From: [Mike Ross](#)
To: [Jeff Watson](#)
Cc: [vkmckim@juno.com](#); [Joe UTCFS](#) "Skvarla"; [Jskvarla@aol.com](#); [Lskvarla@aol.com](#); [dsdsts@aol.com](#); [westerntimber@earthlink.net](#); [Dori Shobert](#); [Kay Muhlbeier](#); [kimperson@live.com](#); [Shirley Kirchan-Person](#); [dalyville@comcast.net](#); [jim@jimuhlbeier.com](#)
Subject: File number Squared up (SP-10-00015.).....Short plat application
Date: Sunday, January 23, 2011 1:14:22 PM

I am an adjacent land owner to the area that has filed a short plat application with the County (file number Squared up (SP-10-00015)). I wish to make it part of the public record that we are against the approval of this application for the following reasons:

SQUARED UP SHORT PLAT
 A PTN. OF THE SW 1/4 OF THE SW 1/4 OF SEC. 24, T.20N., R.15E., W.M.
 KITTITAS COUNTY, WASHINGTON

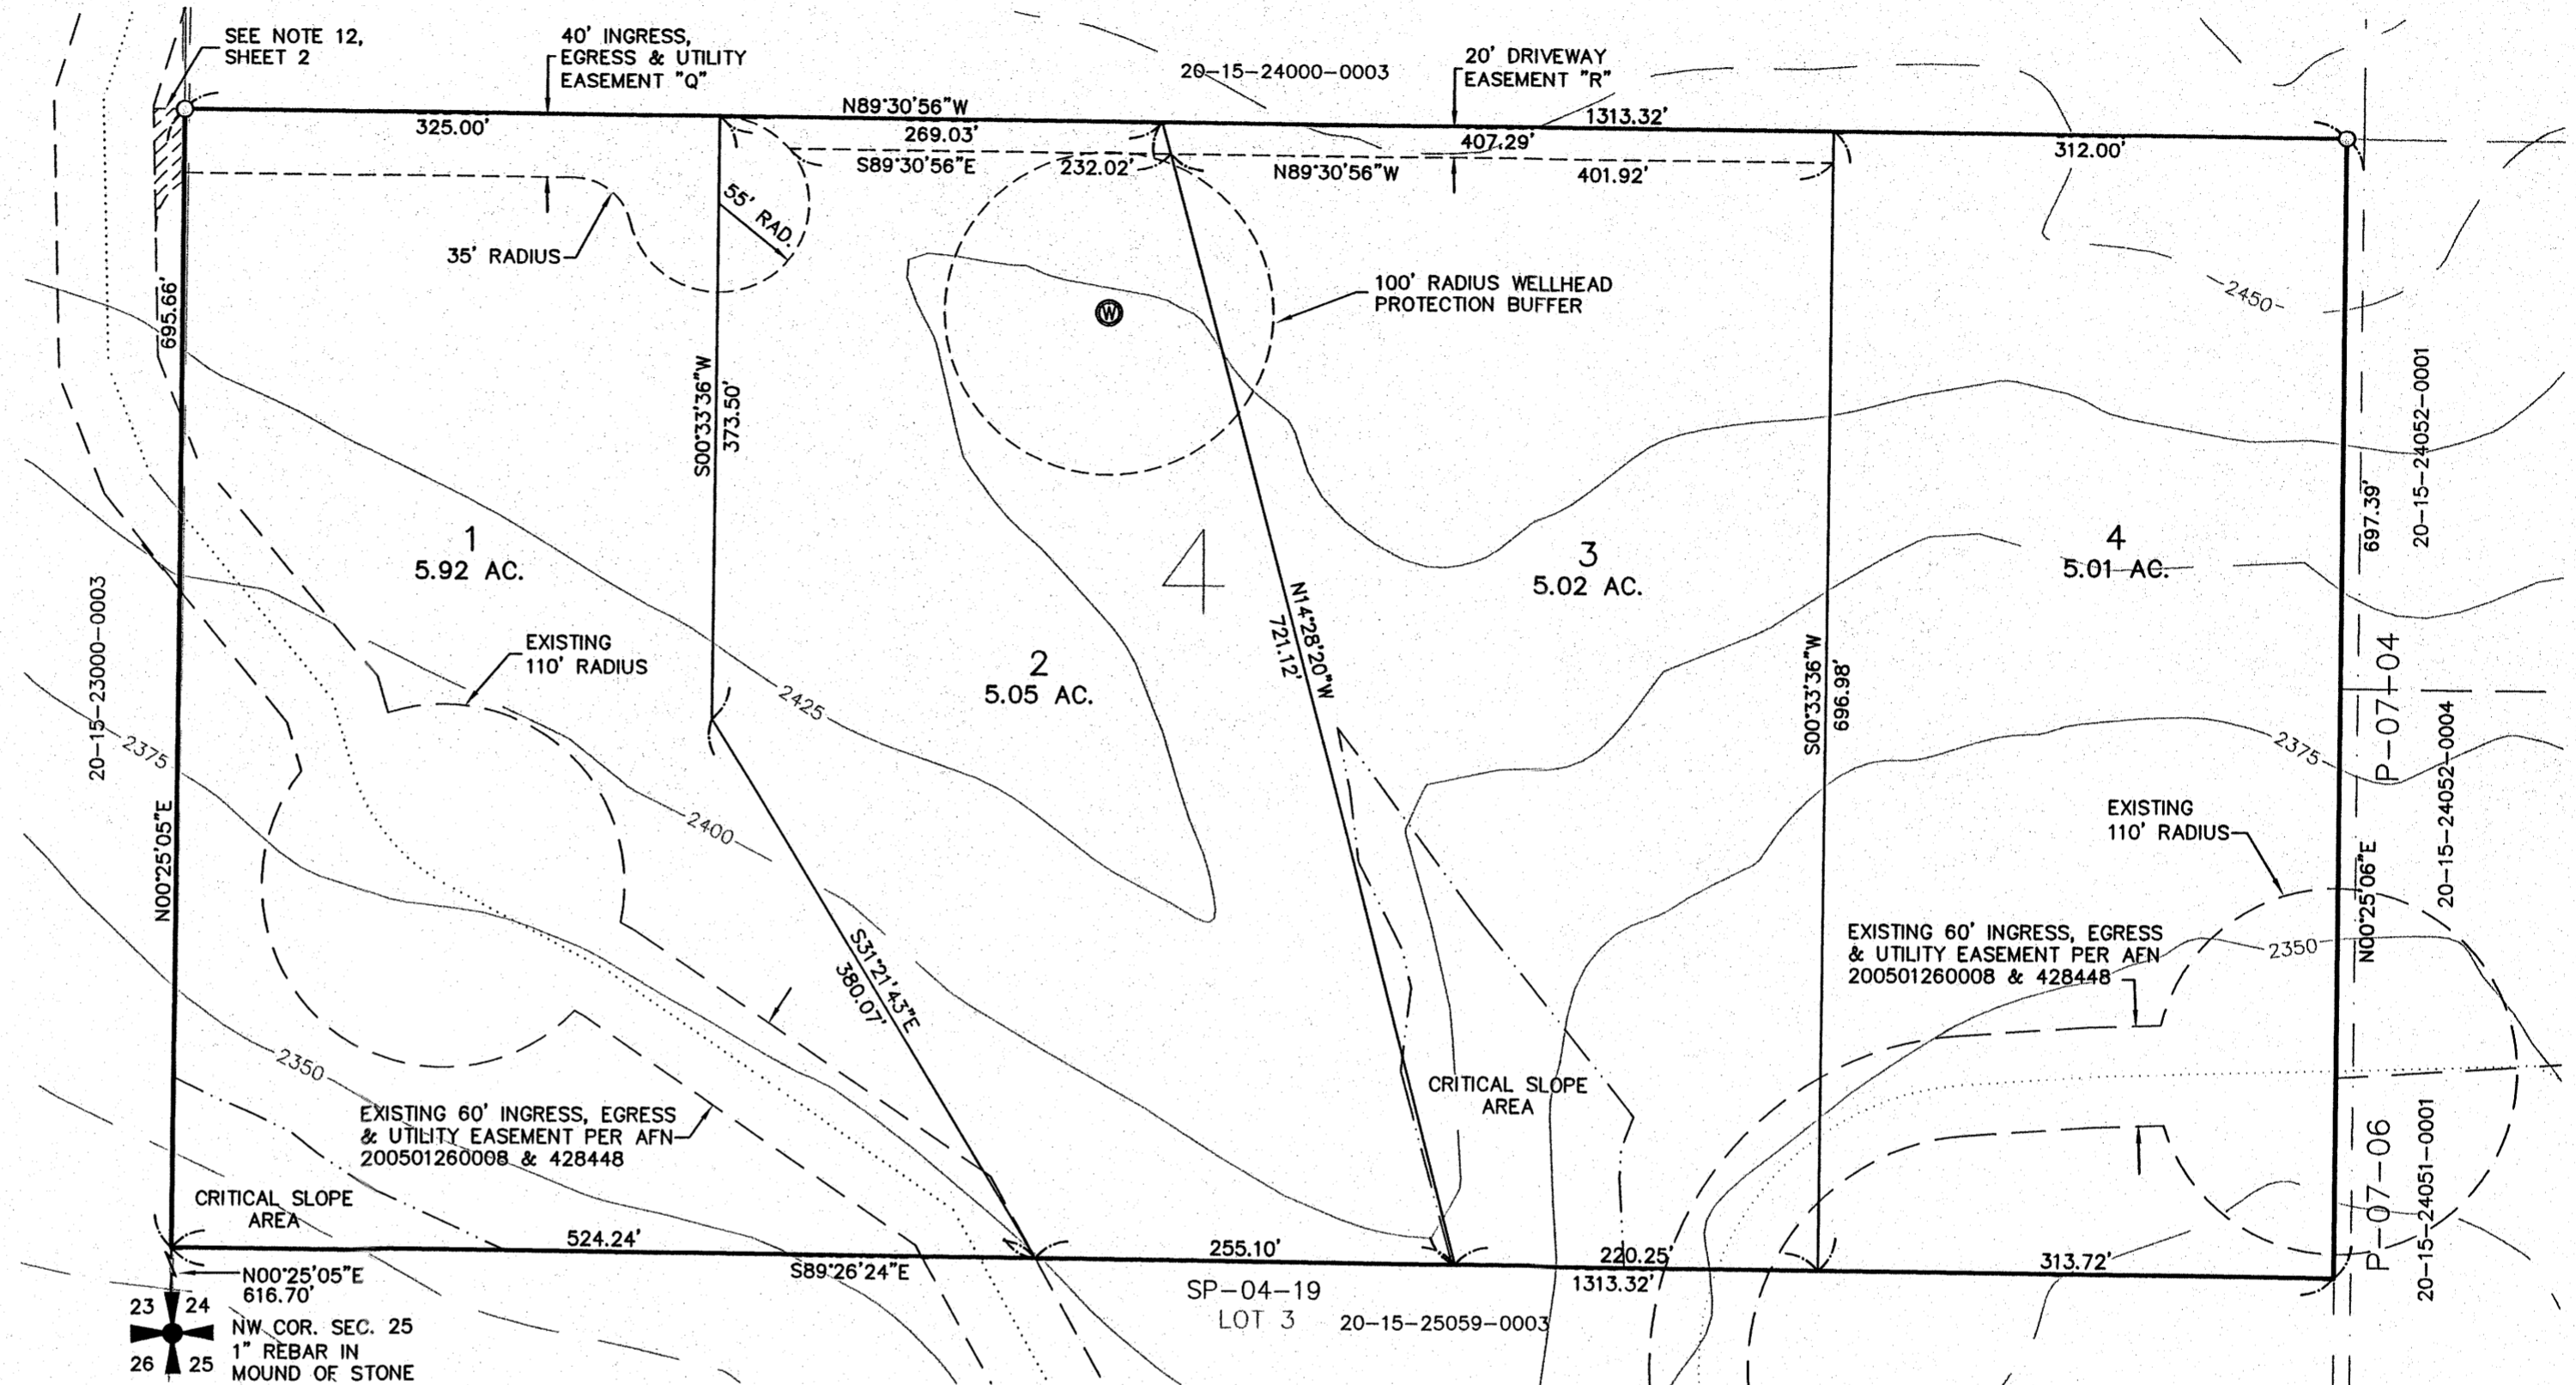
1. Developing this property (21 ACRES) into four additional building lots will impact the limited water that is available in this area above us on the ridge (we have a well that is only producing 2-2.5 gallons and is 750+ feet deep) This has already been discussed at a previous hearing and at that time Cooper Limited (Sapphire Skies) application was turned down due in part to this problem.

2. Once again a developer wants to use our Private roads (with private gate) as a secondary access and will surely use this much shorter route from town for construction equipment etc as a primary route. If you had a choice of a paved road half the distance to town or a rural unpaved road which would be your choice? The environmental impact of more traffic on this road needs to be addressed along with the cost associated with the plowing and maintenance. Will it be in the deeds that they too are responsible participants of these roads.and should be responsible for the costs involved

3. Short platting this area on the assumption that the owners can get water rights (which I believe are close to selling out) and have viable water if they do is irresponsible for the county to approve since the building permits may not be possible.

4. The so called easement is presently not developed, not even passable by car and currently has drainage issues (since road on top was graded) that now collects at the corner of our property. We also would like to be informed of how P Squared LLC is planning on the future up keep and maintenance of this easement if approved.
